Application No: EP/47/21/HH
Site Address: West House South Strand East Preston BN16 1PN
Description of works: Erection of second floor addition, part single storey side, part two storey front, side and rear extensions and alterations to fenestration/openings

Thank you for your internet representation made on 10th June 2021 which has been recorded as an objection with the comments as follows:

I am commenting on behalf of the East Preston and Kingston Preservation Society.

**W ELEV**

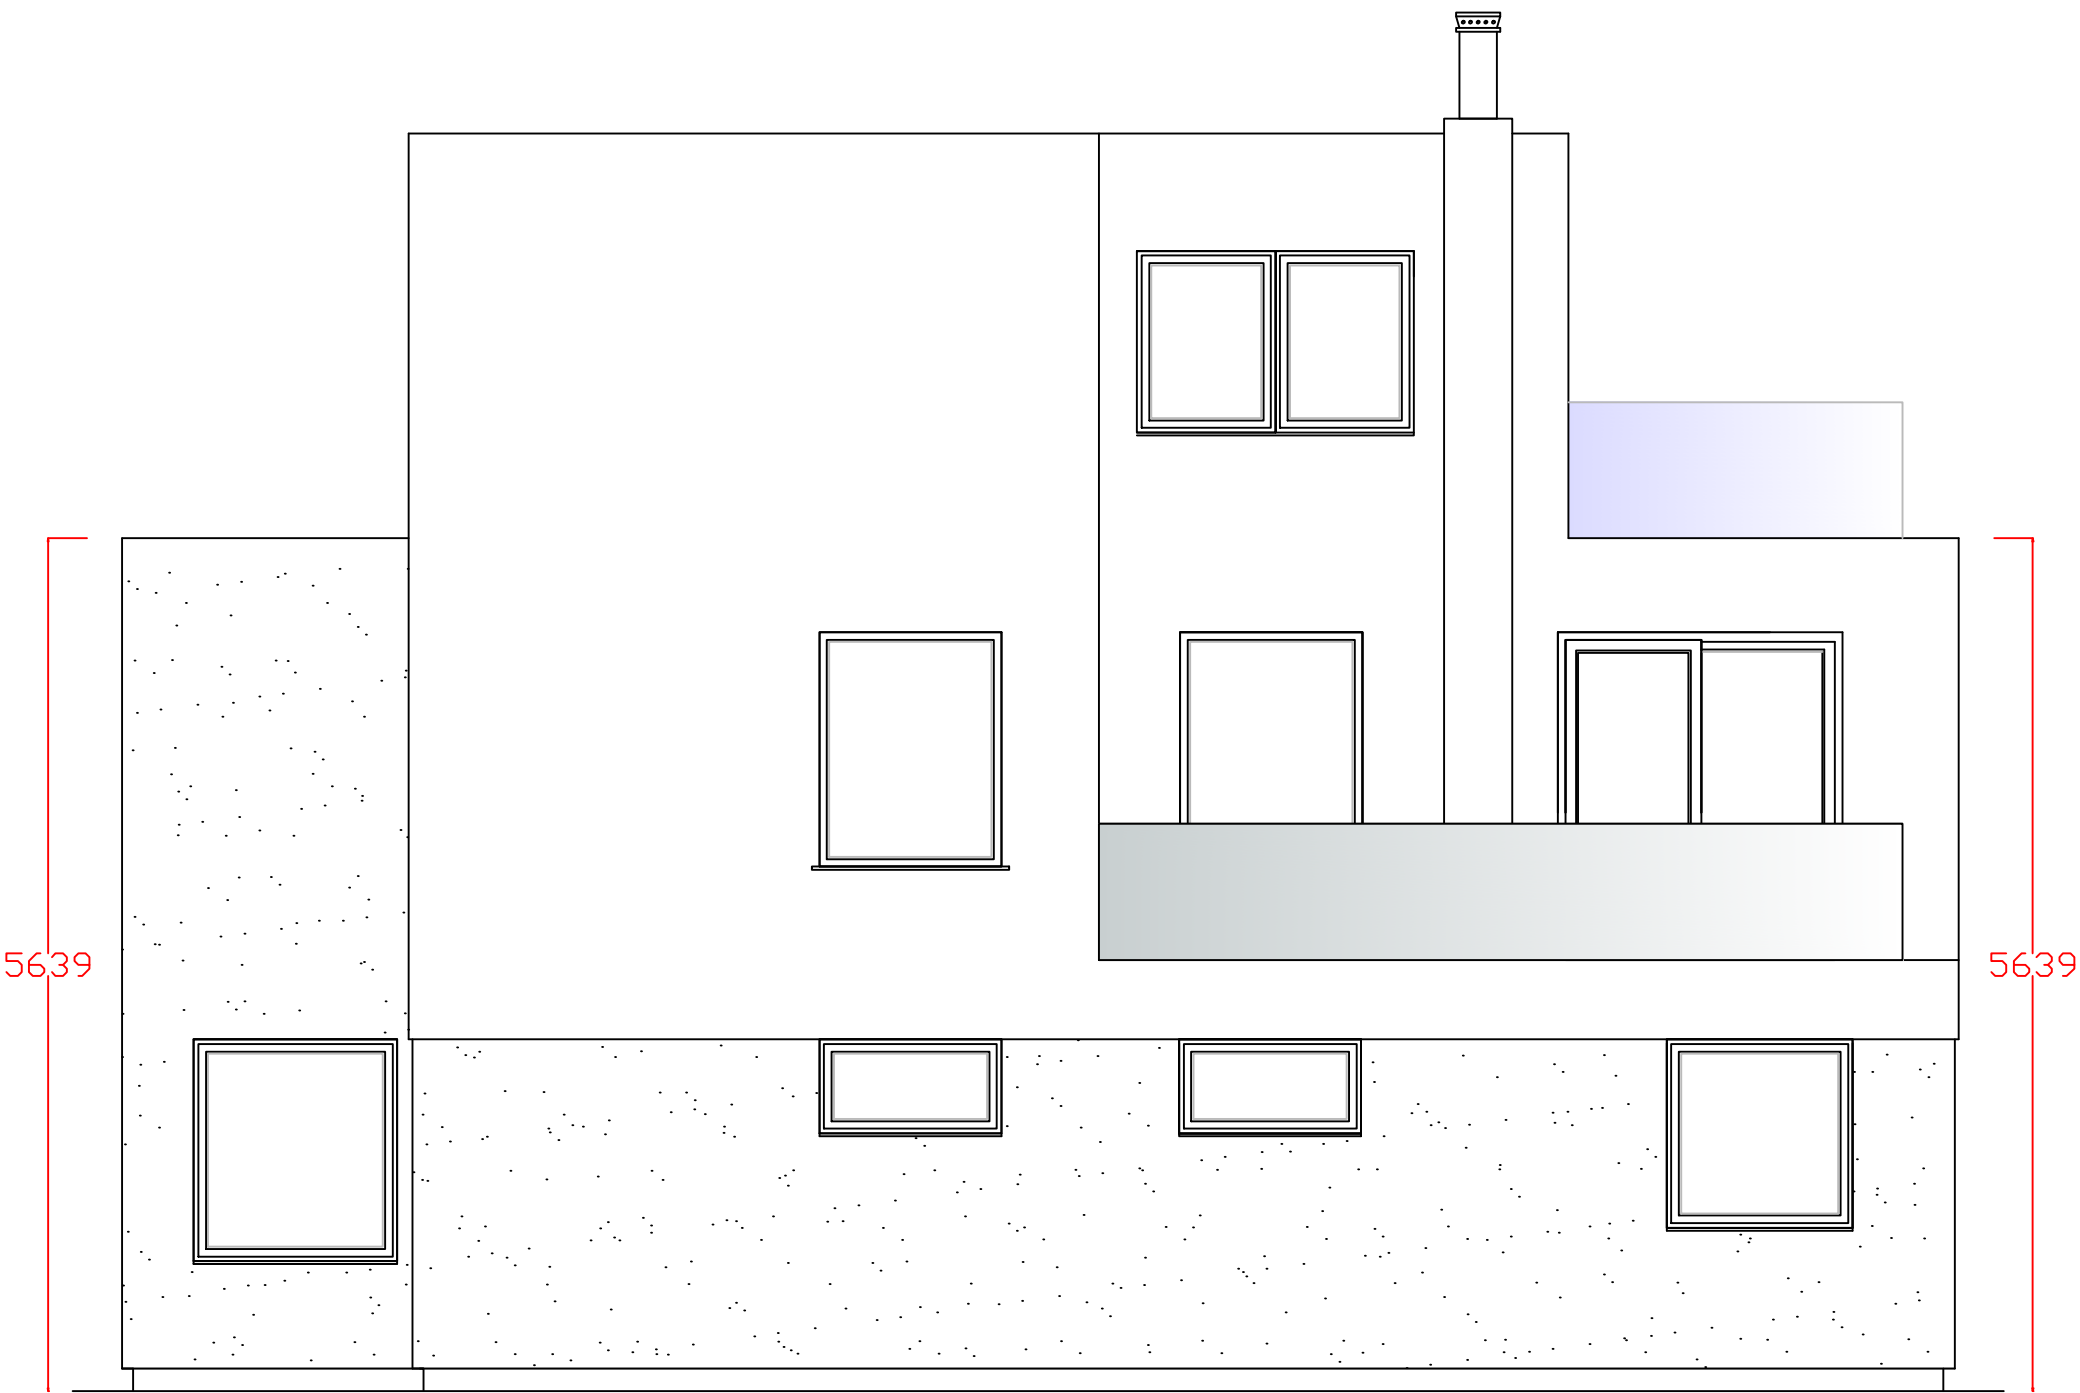
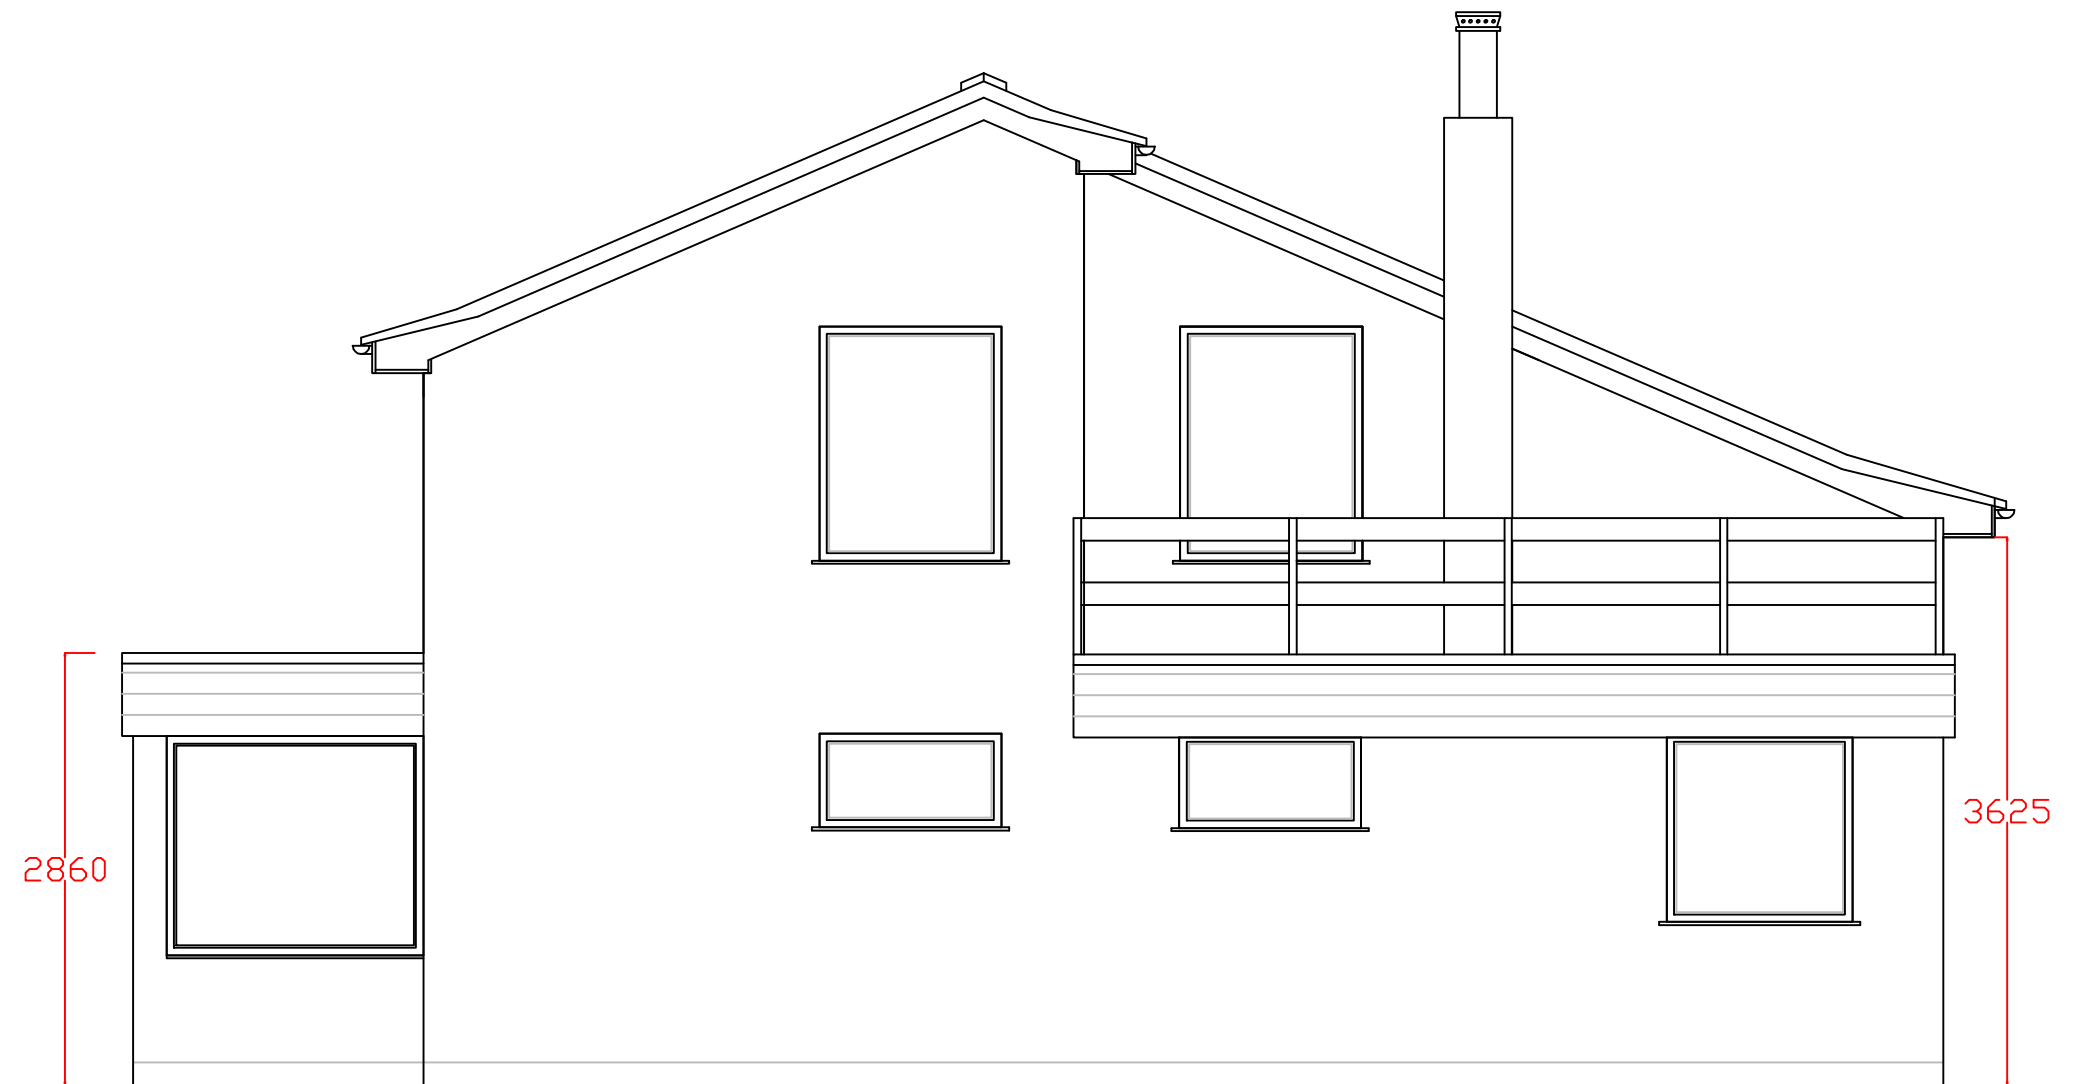
The design, materials and height of the proposed building would contravene both policies D DM1 and DM4 of the Arun Local Plan, because they do not reflect the character of the buildings in the surrounding area. The enlarged and heightened house would also overlook its neighbours to the south and west.

S ELEV

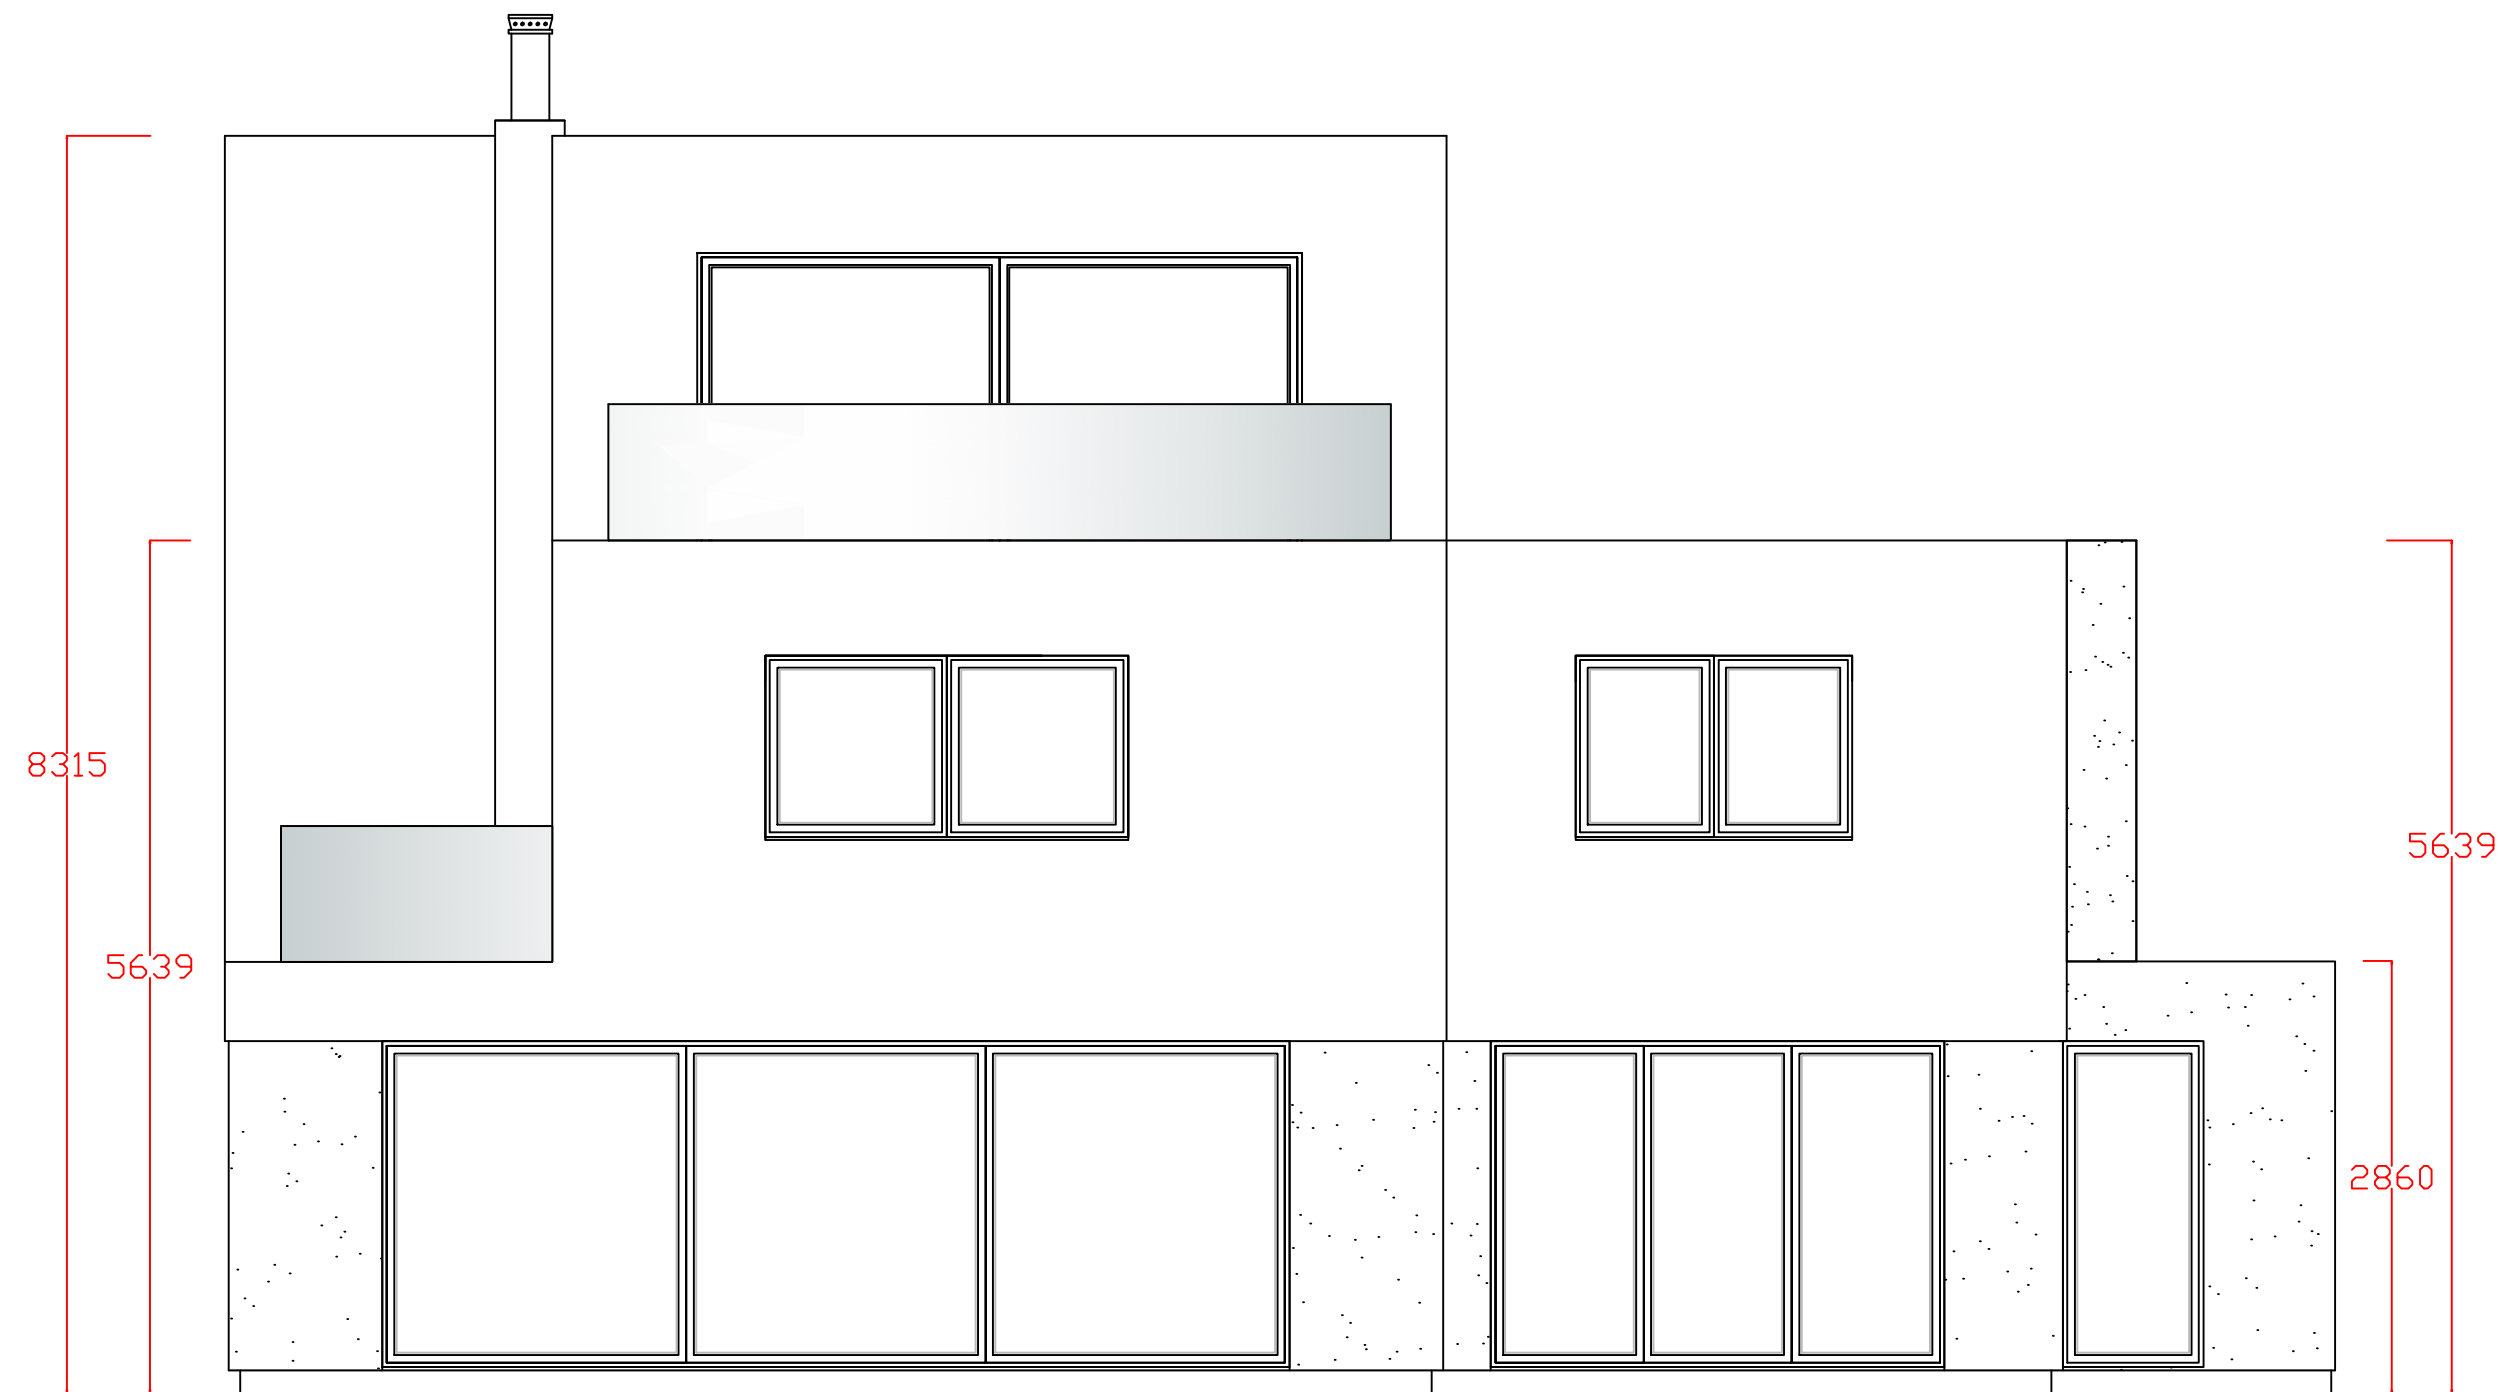
The proposal would contravene Policy 1 of the East Preston Neighbourhood Plan, because the scale, massing, height and materials would not reflect the architectural and historic character and scale of the surrounding buildings. It would contravene Policy 2 of the Neighbourhood Plan because its scale, massing and height would harm the street scene and the view from the beach.
